From: [REDACTED]
Sent: 21 February 2019 10:37
To: Sian Eggington
Subject: Re: Further Information Required on Your Ref: PP-07578429 Our Ref: LY/1/19/HH
Attachments: new doc 2019-02-21 10.30.04_20190221103032.pdf; new doc 2019-02-21 10.30.53_20190221103129.pdf

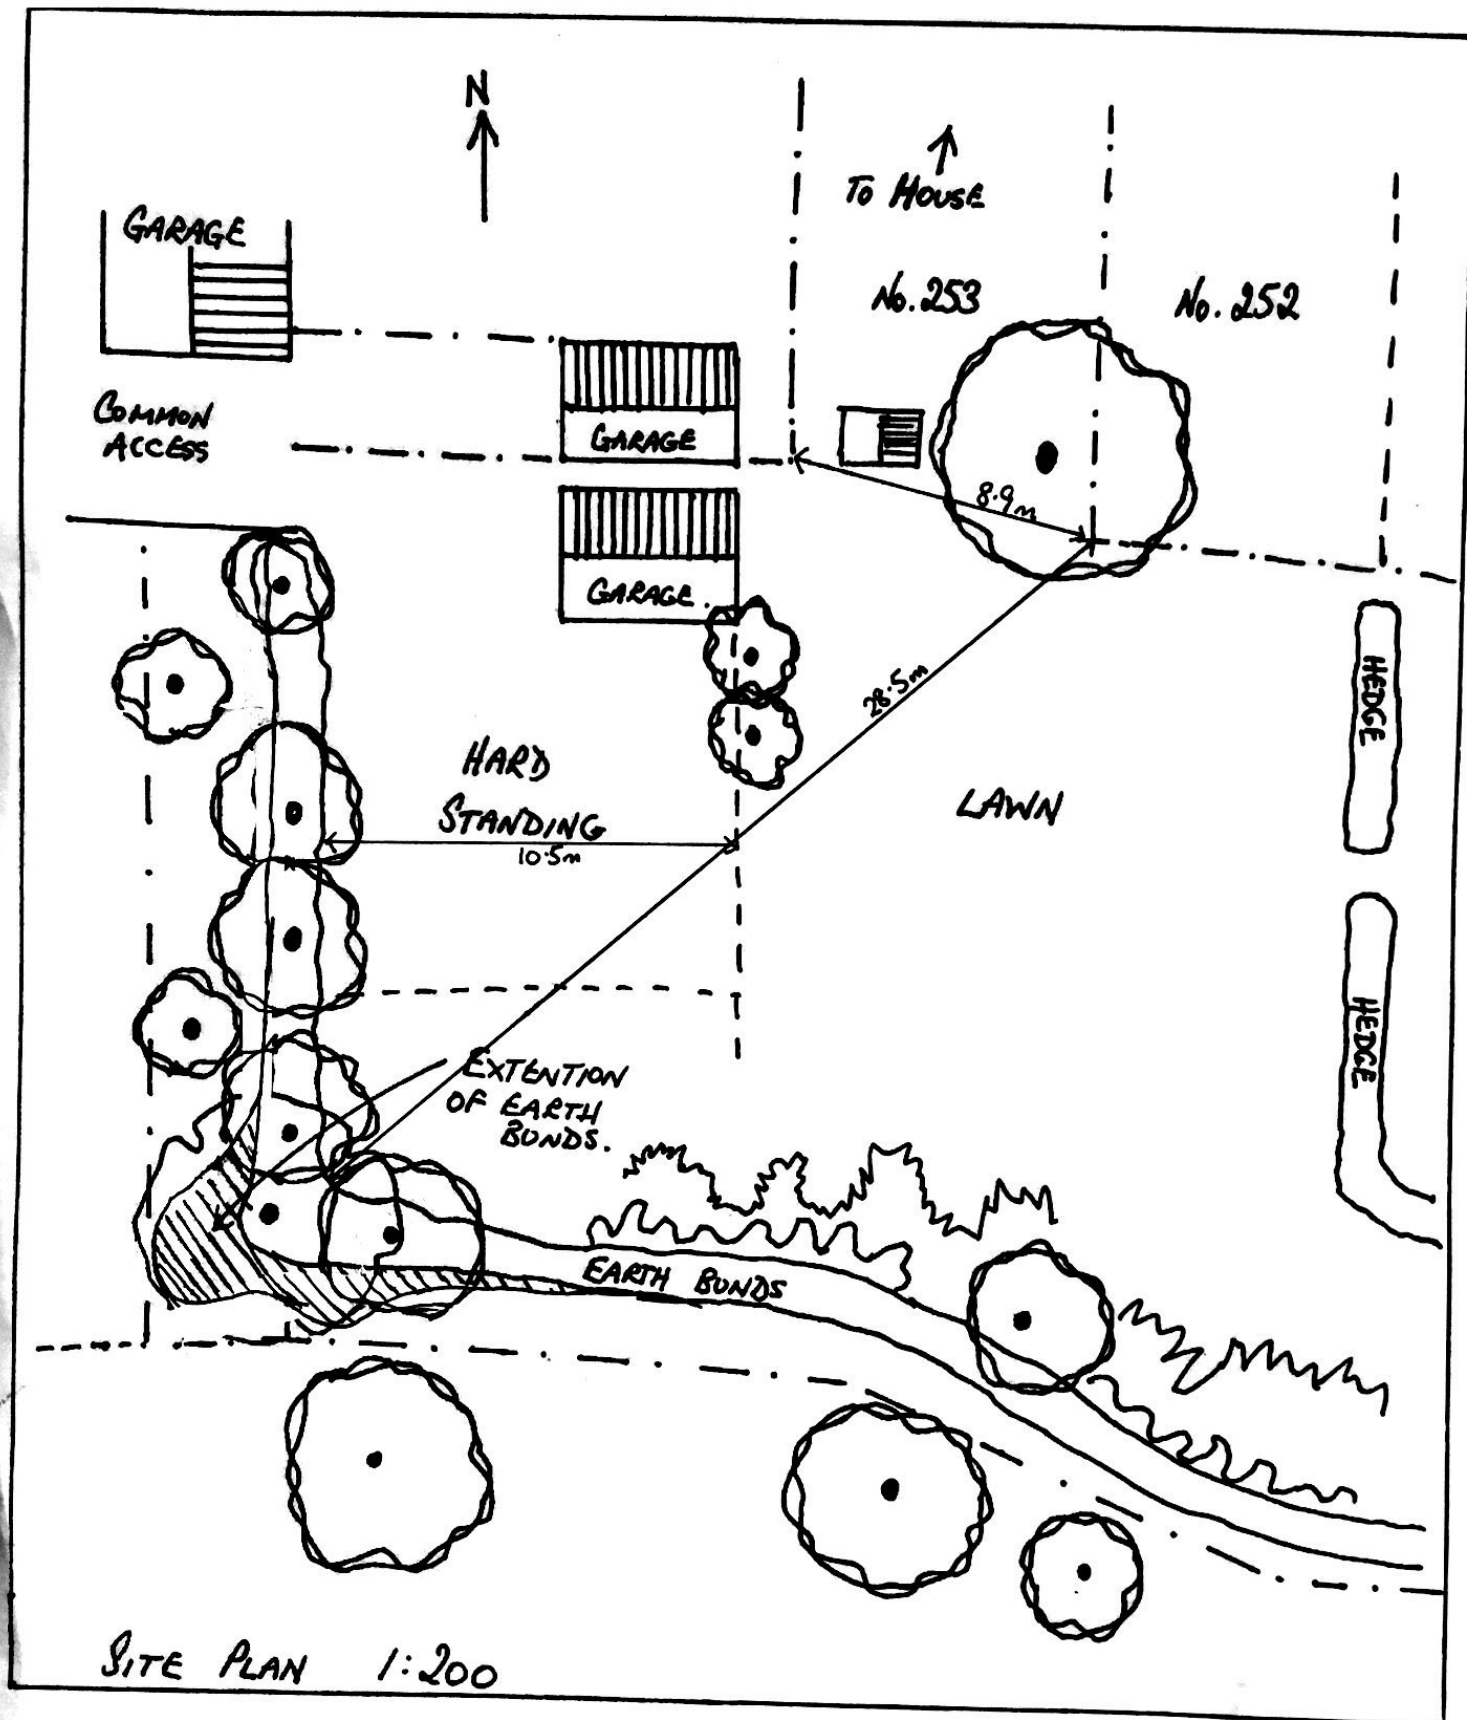
Thank you for your email. Those plans are all fine now, however we still require a section/elevation of the earth bund. I have attached a similar drawing for guild lines. The drawing does not need to be the whole of the earth bund it just needs to show a section like below and does not need to be detailed it just needs to show the height annotated onto it as a dimension. The drawing needs to be to scale i.e. 1:100 or 1:50. There are other examples on google to help with this.

I have made a scaled drawing through the earth bund, as shown on the revised Site Plan. Through section AA.
